Ref/Job No: 11SYDECO-118

August 8, 2012

Re: Issues to be addressed in the Preferred Project Report for the Lakes Estate, North Boambee, Coffs Harbour Future Subdivision

CHECKED	DRAWN	SCALE	
KS	DD	0 25 50 100 150m	
PROJECT NO.		SCALE 1 : 5000 @ A3	
912	-	DWG No.	REV. No.
		A004	G

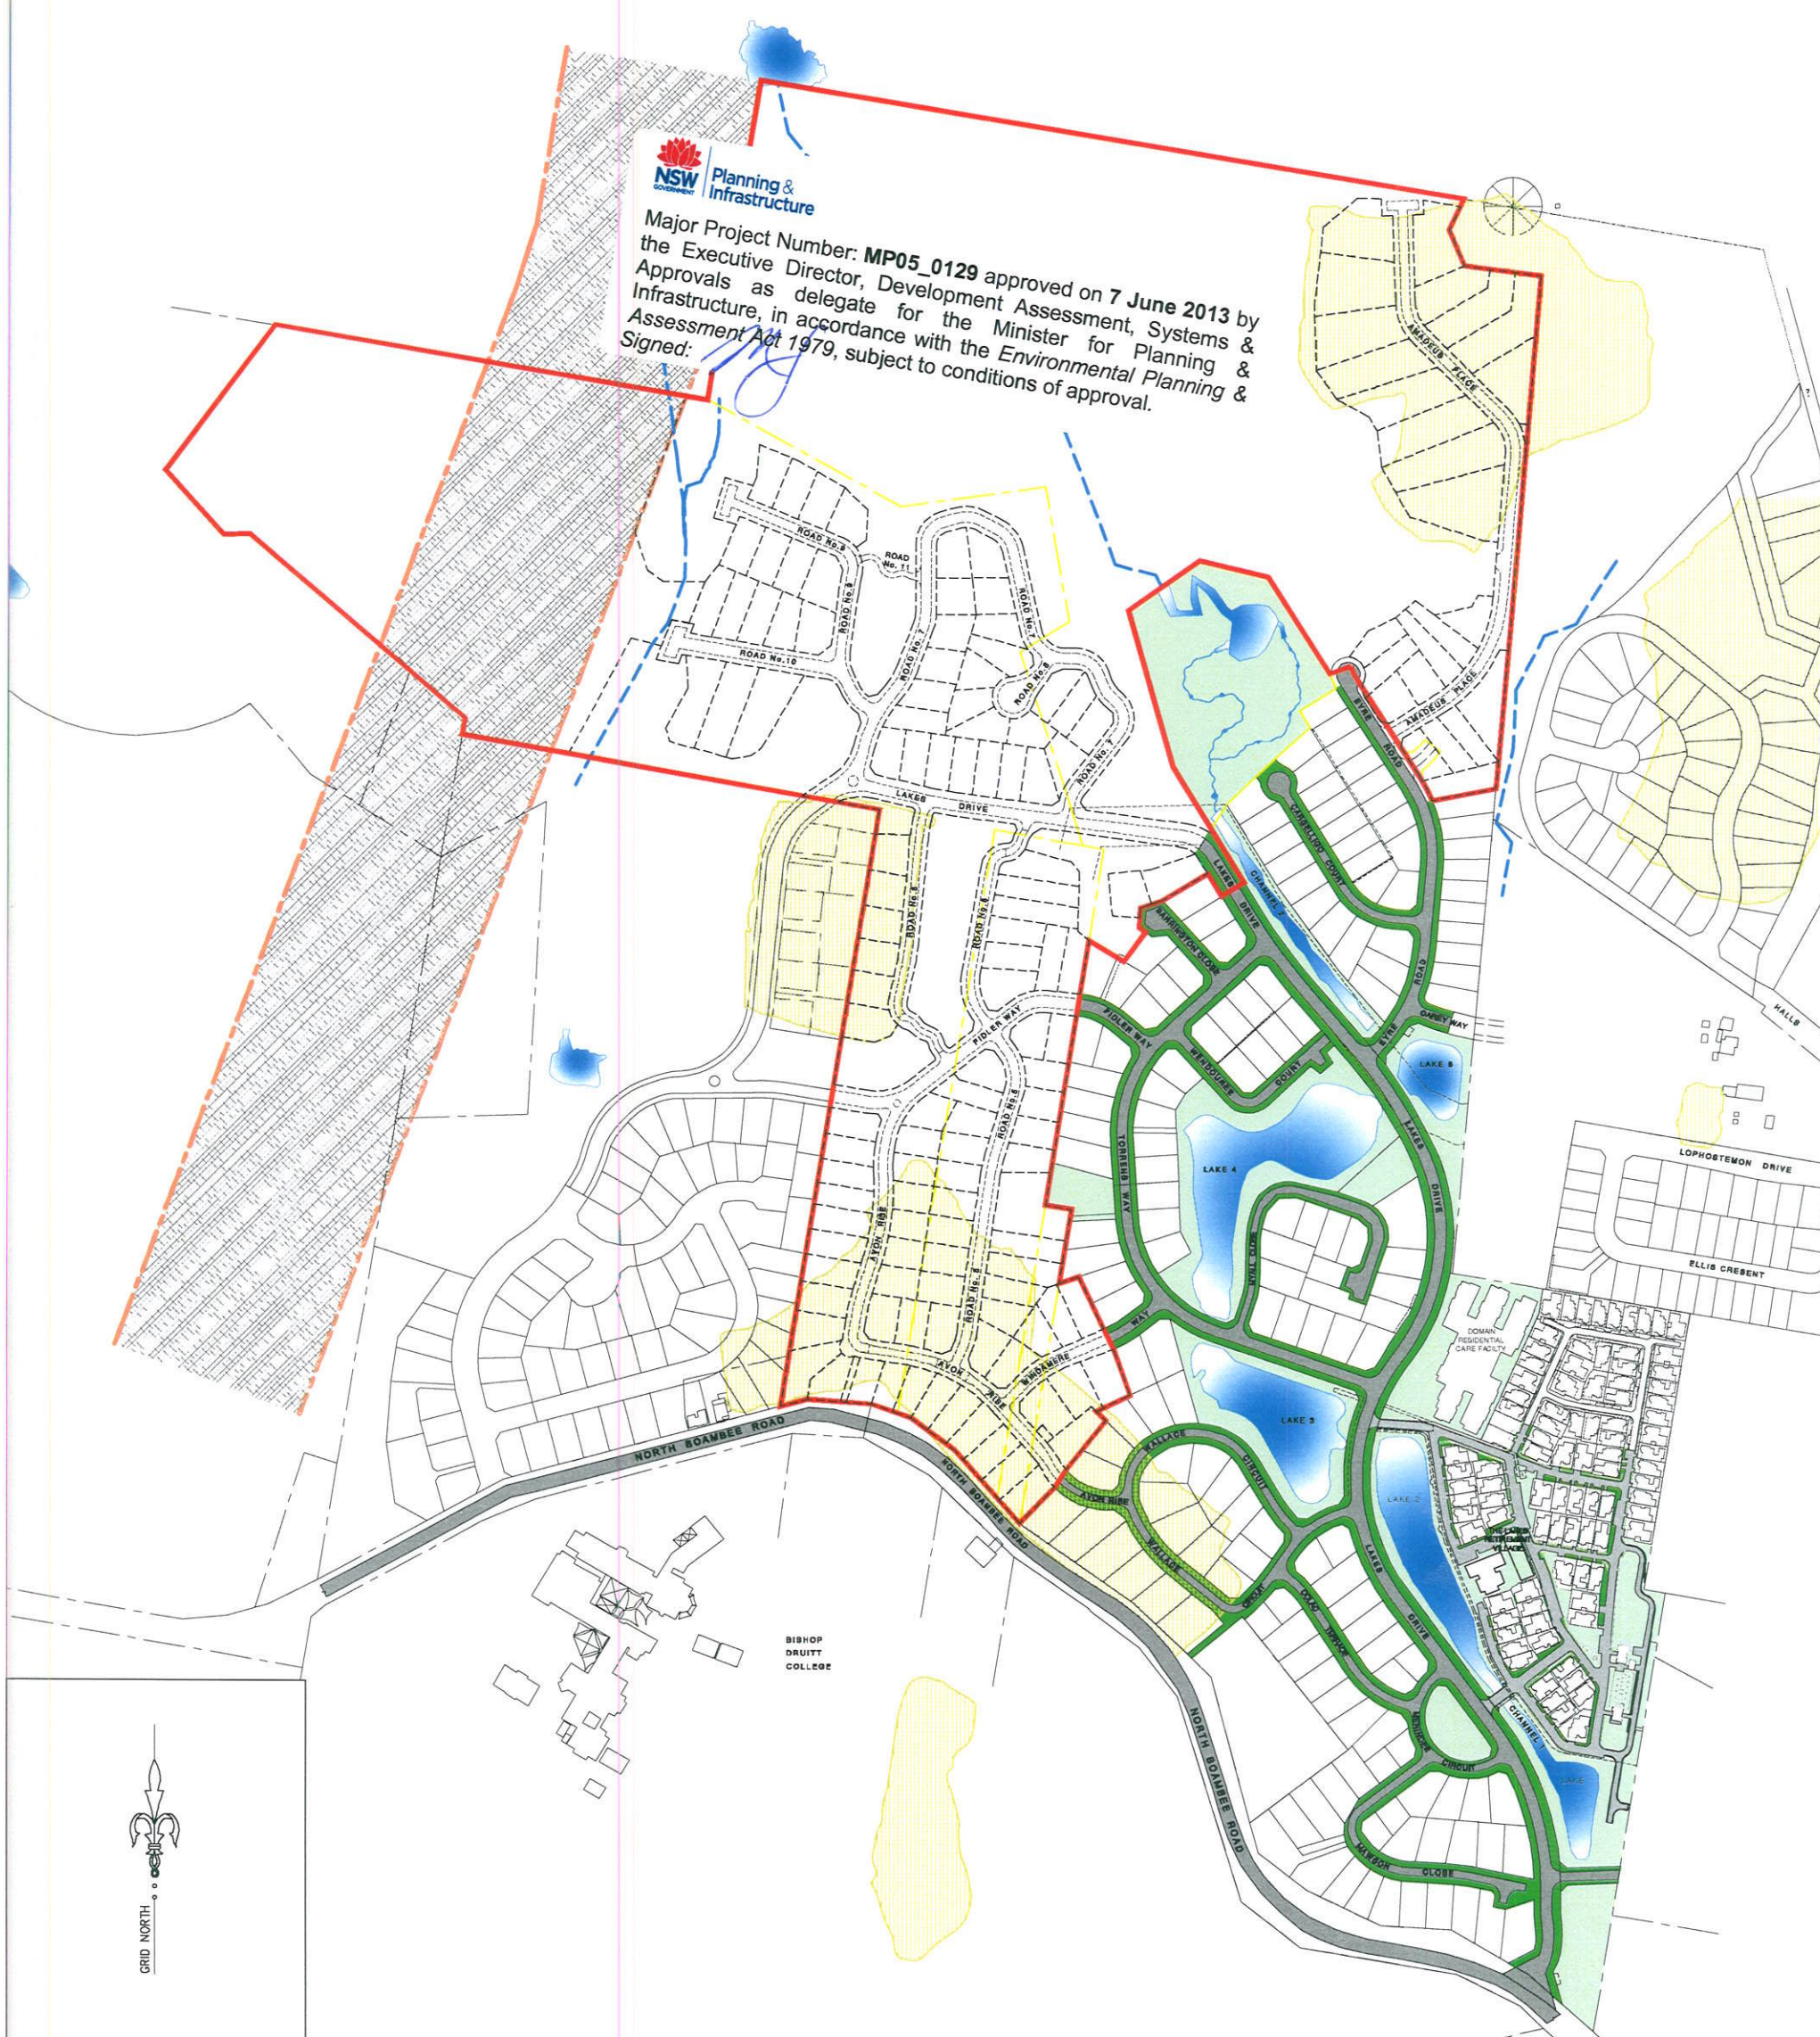
We note from the Koala habitat plan (912-004C) that the general approach has been to design the subdivision layout by avoiding tree removal or pruning of trees so as to minimise impacting on existing Koala habitat throughout. The noted exception to this is the southernmost stand of trees that are generally disconnected, relative to the principal bushland areas and corridors, where the bushland is proposed to be confined to an identified park area.

CHECKED	DRAWN	SCALE	
KS	DD	0 25 50 100 150m	
PROJECT NO.		DWG No.	REV. No.
912		A008	H

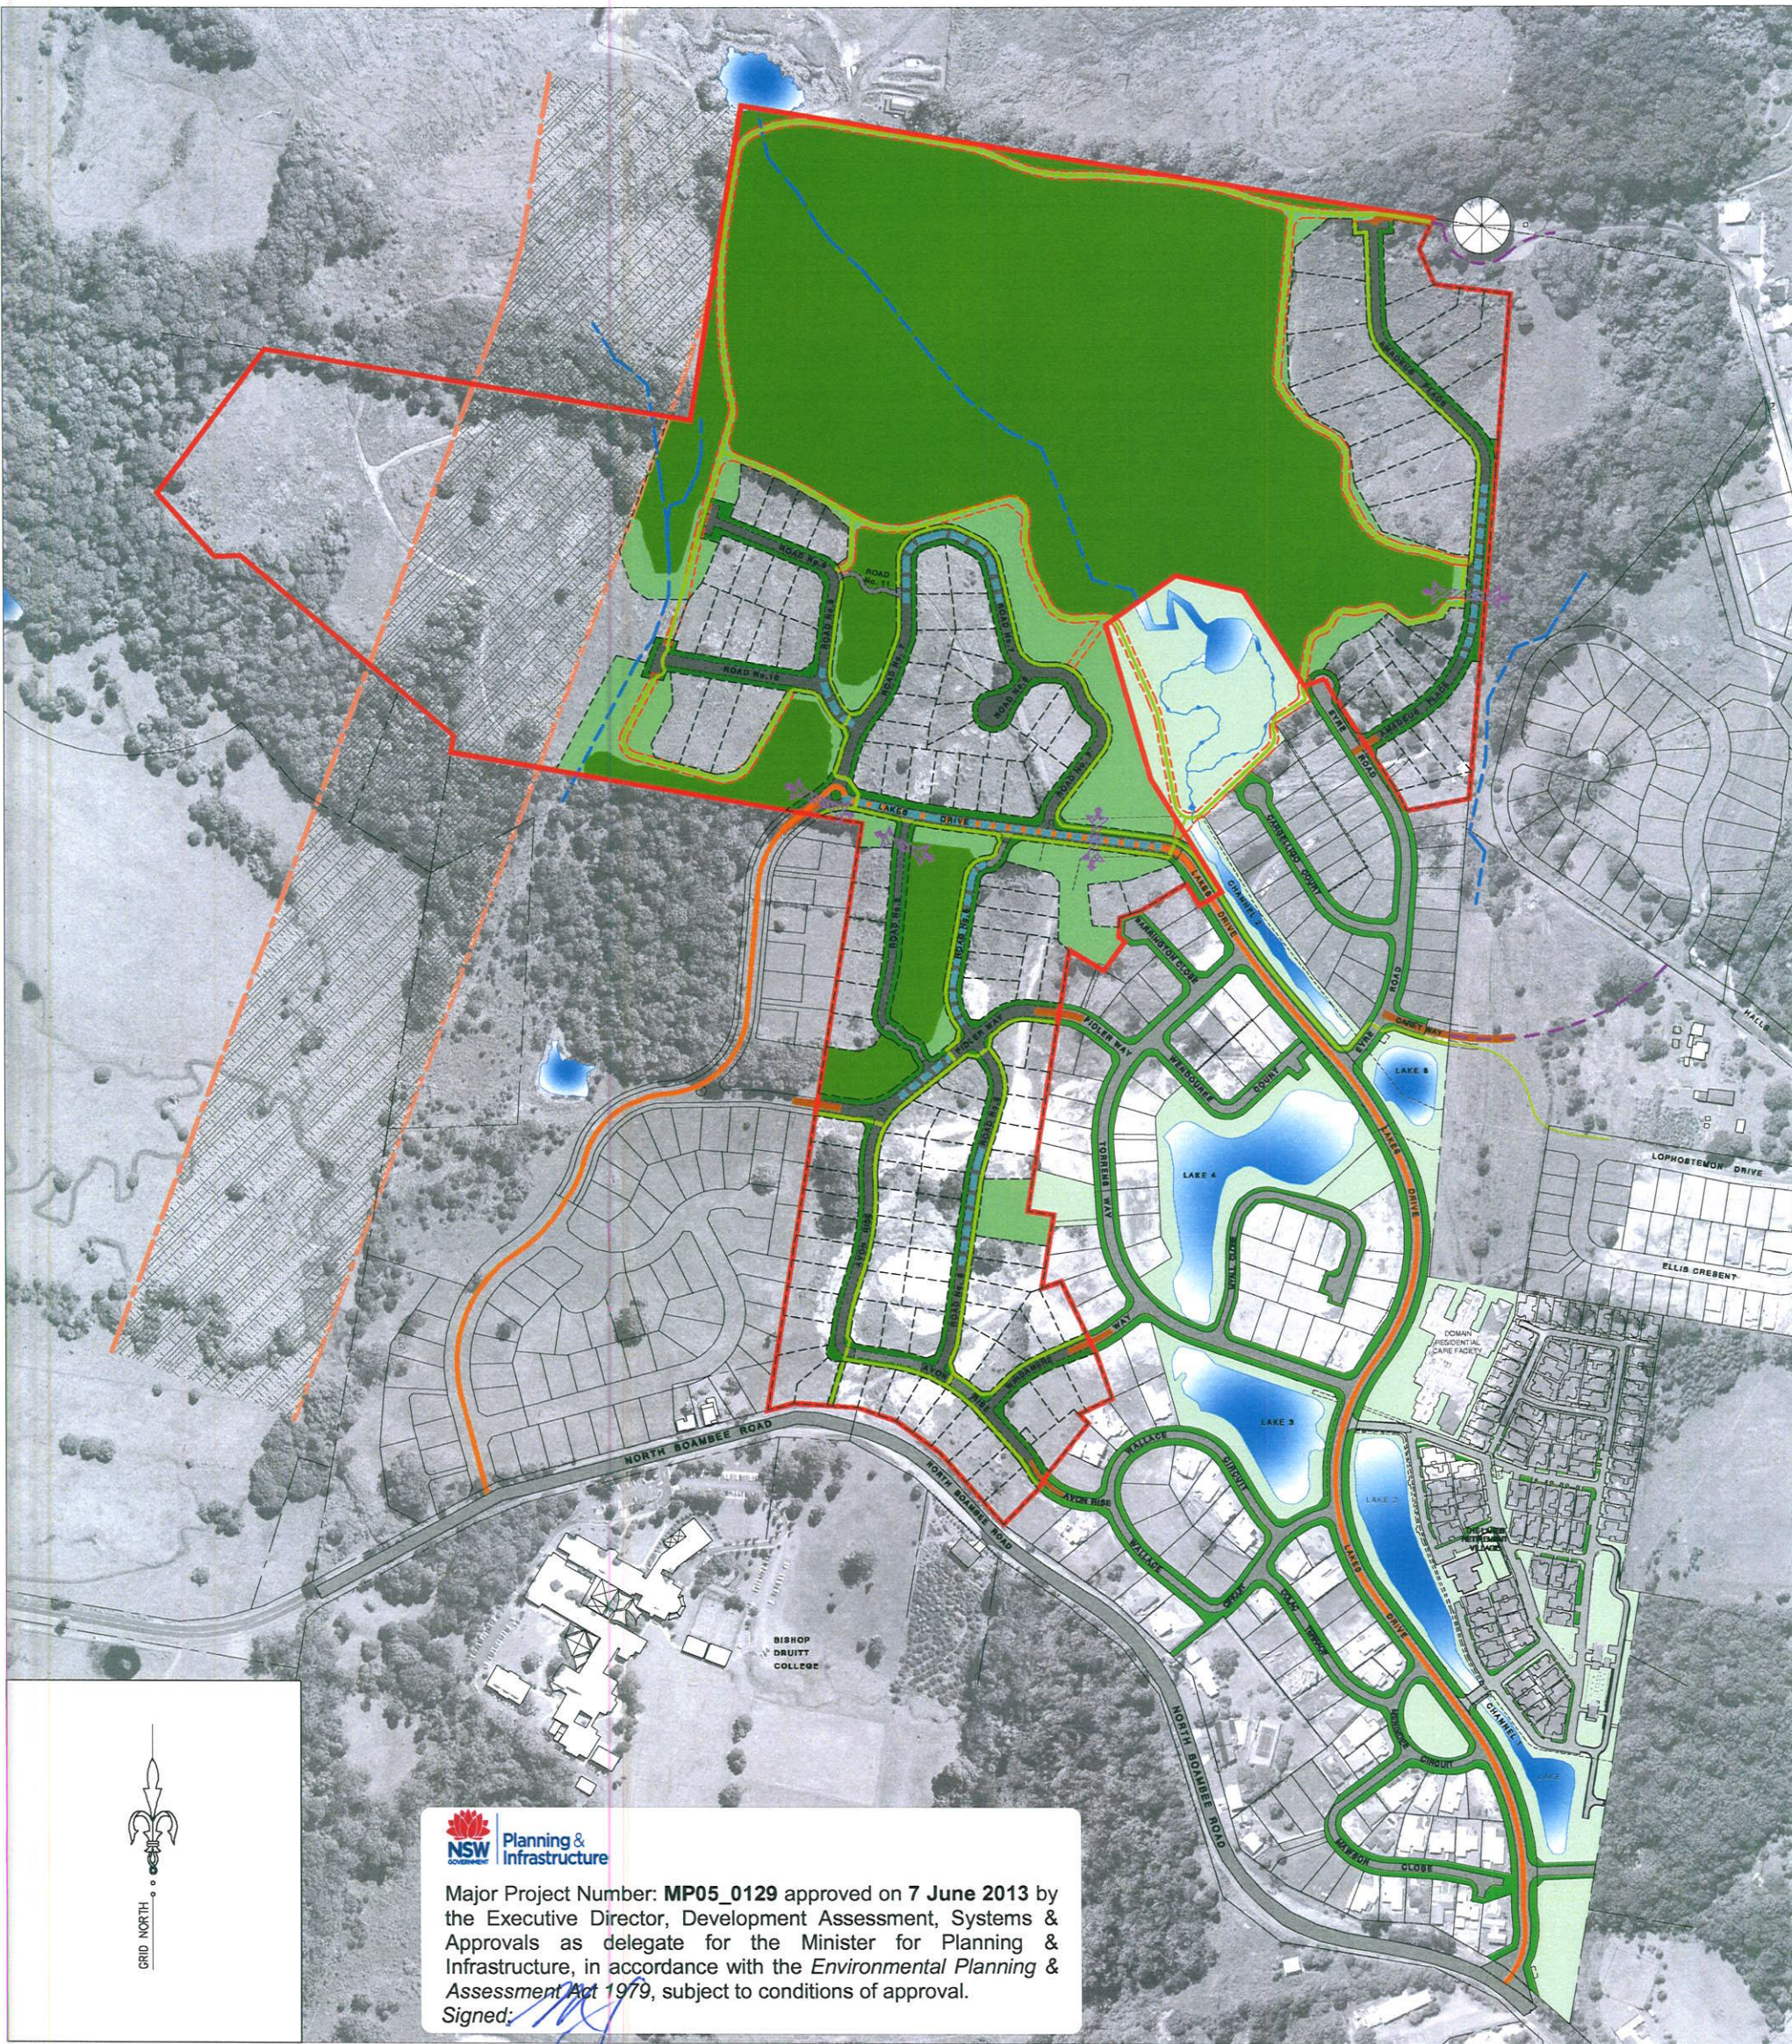
The development of restricted traffic flow areas to provide appropriate slow points is considered an appropriate mitigation measure against death and injury to Koalas. The areas identified by the roads and movement access plan are considered appropriate. We have identified some additional areas and have also recommended the placement of Koala movement culverts at key locations within the subdivision. These have been incorporated in

plan 912-A008E – Roads and movement access plan. Slow points and Koala culverts should be implemented using best practice and guidelines published by Council.
